**Application Number SSI 7485****WestConnex M4-M5 Link – Modification 2 The Crescent overpass**

**Paul Connor**

Figure 4-2 Pedestrian and cyclist bridge infrastructure options

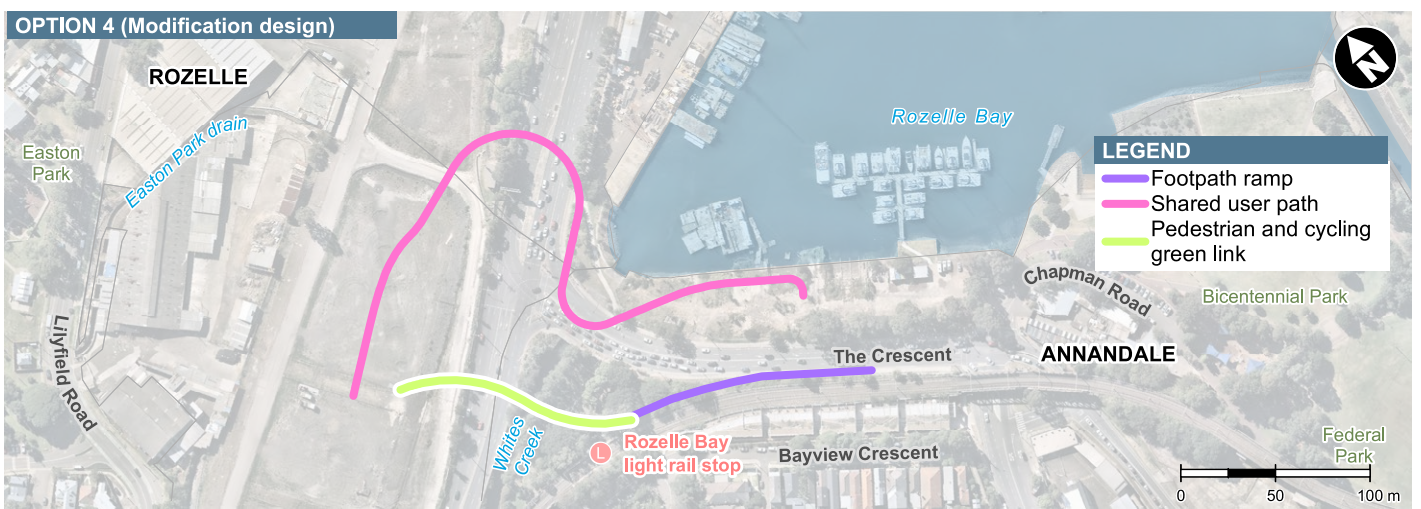
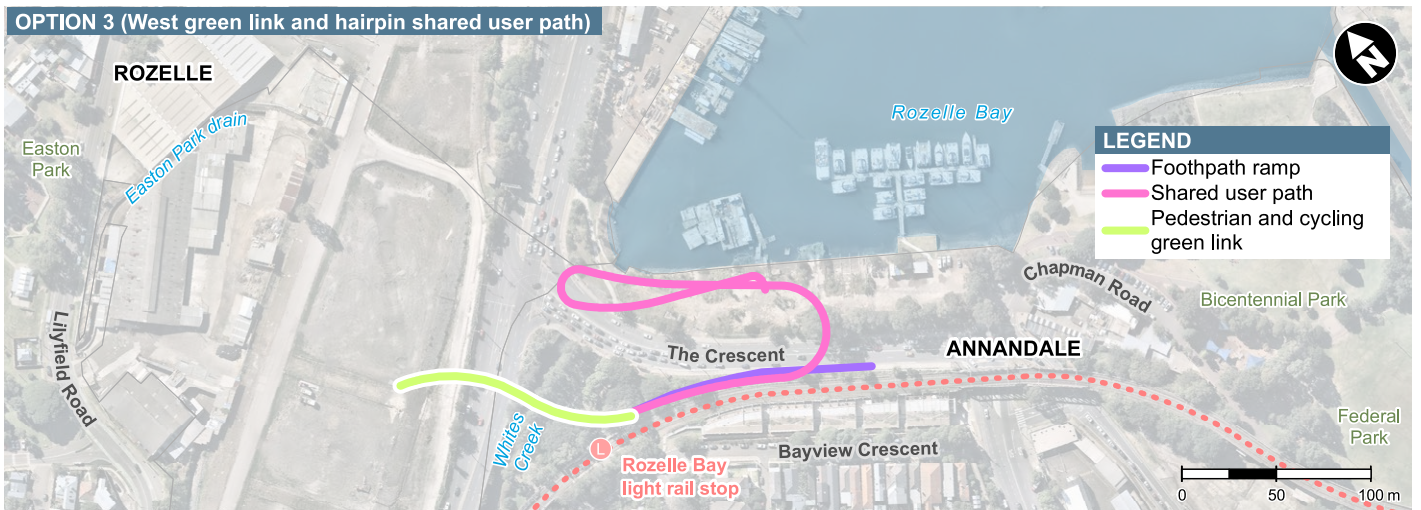
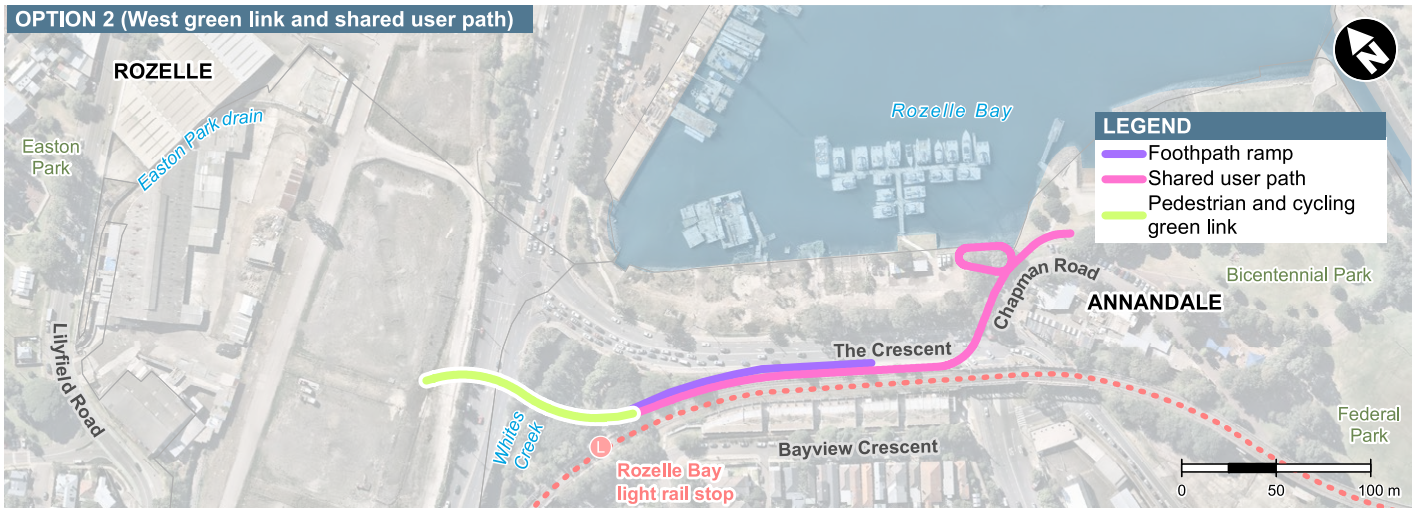
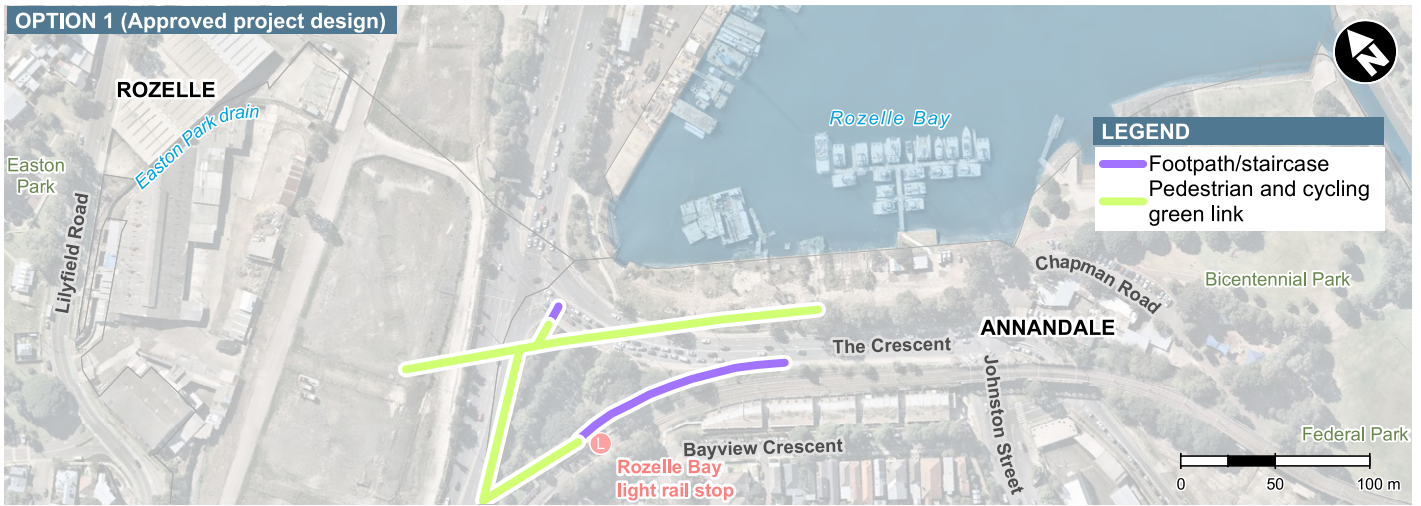
The proposed shared cycle/pedestrian overpass at the Crescent in Annandale is a missed opportunity, representing a poor design outcome for a significant site on the foreshore of one of the world's great harbours.

It is also not best planning practice. Austroads guidelines recommend *shared paths should be used only where user numbers and cycling speeds are low*, and VicRoads is revising their recommendation to recognise that *separated or well segregated paths better cater for high numbers of users*. The shared pathway on the Anzac Bridge is a demonstrable failure, rendering it unsafe for the elderly, the young and the mobility impaired due to the proximity of cyclists.
